**SOIL/SITE EVALUATION
 for ON-SITE WASTEWATER SYSTEM**

Owner:
 Address:
 Proposed Facility: 4BR
 Location of Site: Leigh Laurel
 Water Supply: Public Individual Well
 Evaluation Method: Auger Boring Pit
 Type of Wastewater: Sewage Industrial Process

Applicant: Hope + Branden Tyndall
 Date Evaluated: 3/21
 Property Size: .75
 Property Recorded:
 Spring Other
 Cut
 Mixed

SITE PLAN APPROVAL

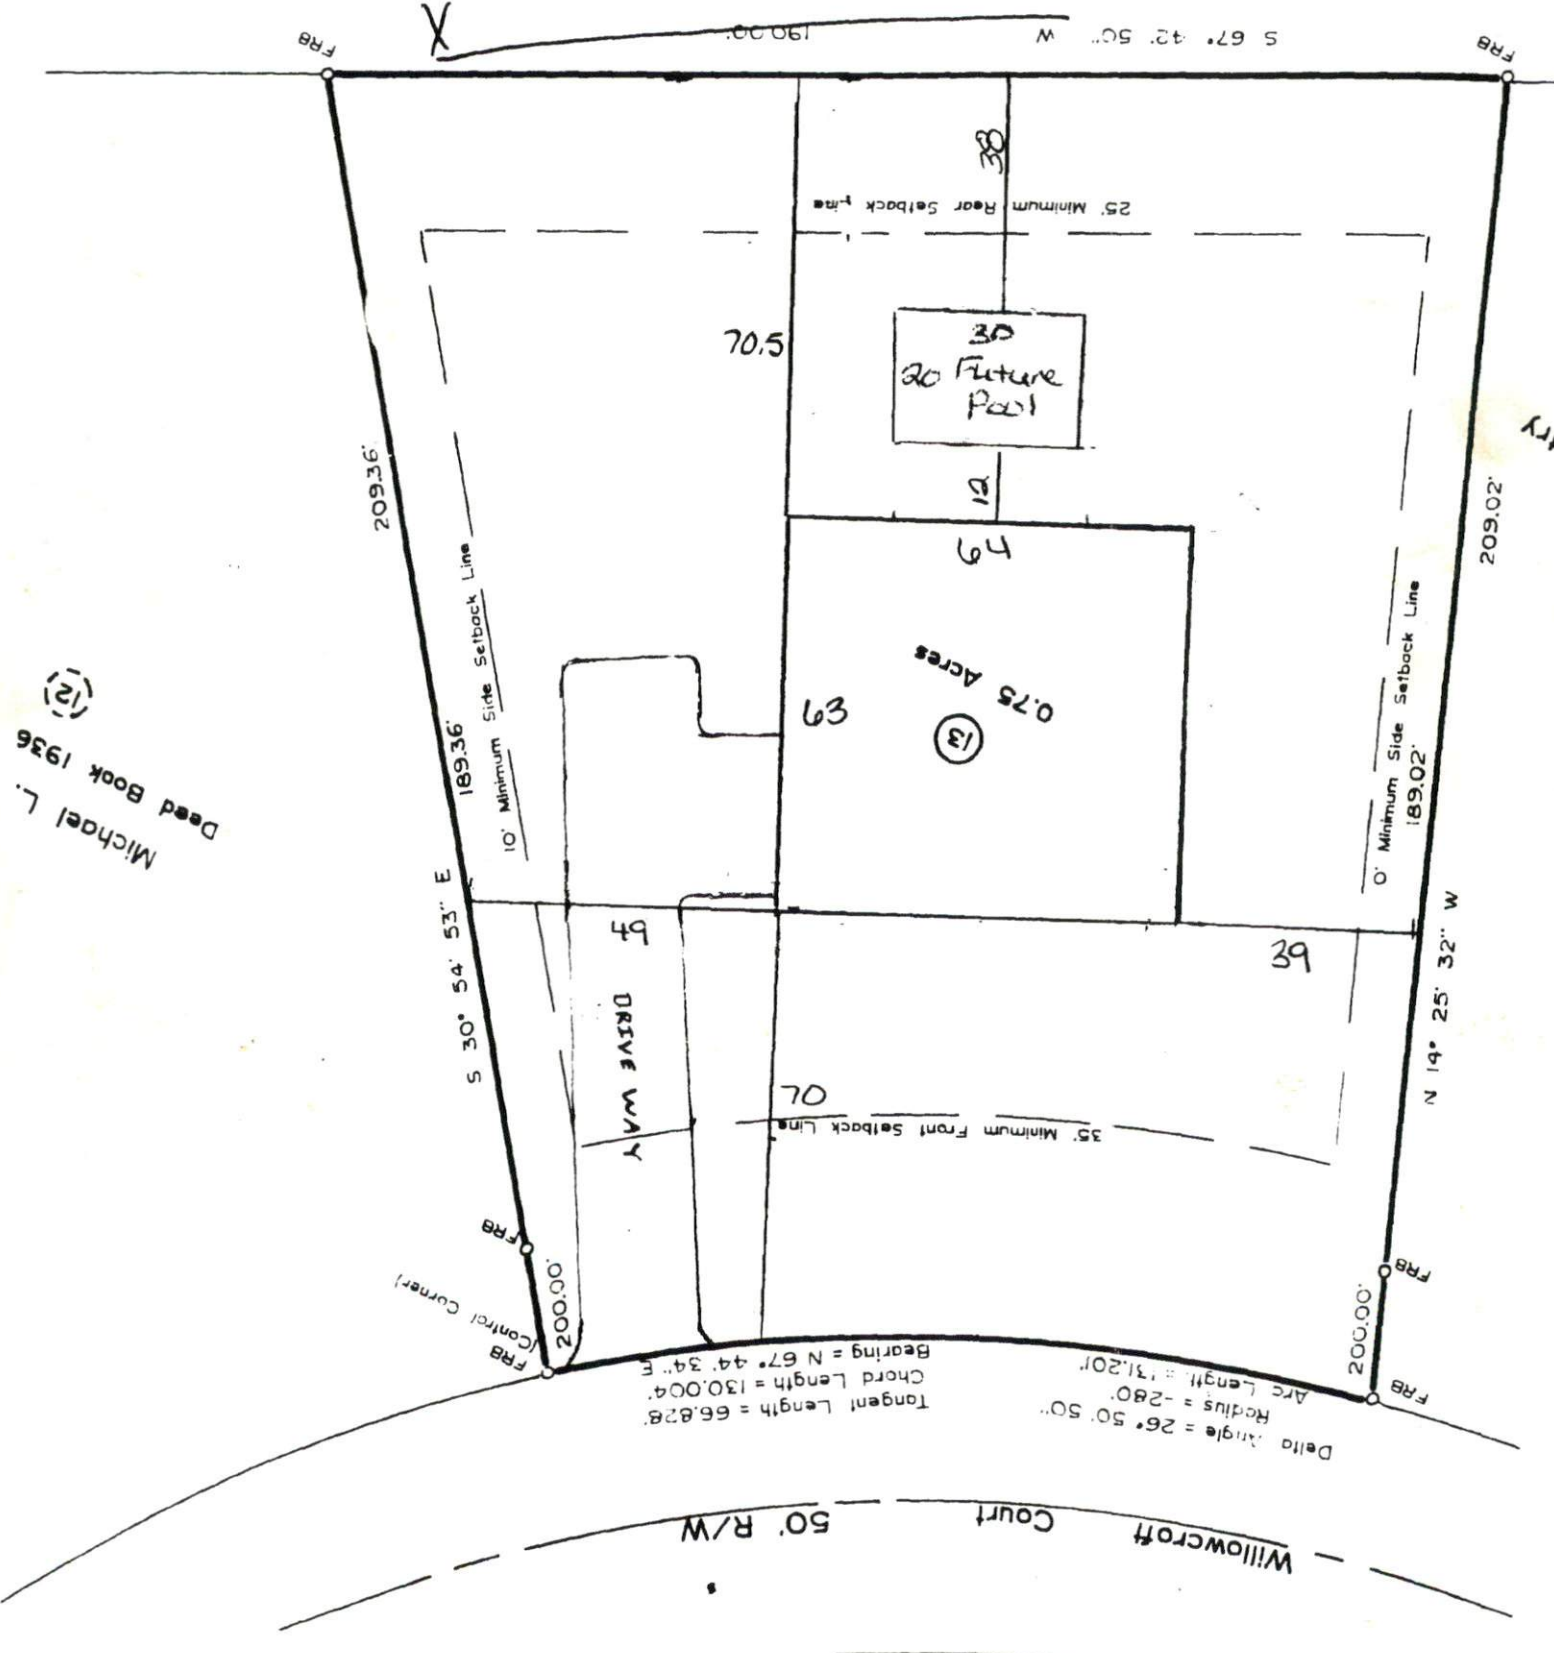
Other Factors (.1946): Deck not shown
 Pool on app must be moved.
 Site Classification (.1948): PS
 Evaluated By: WHC
 Others Present:
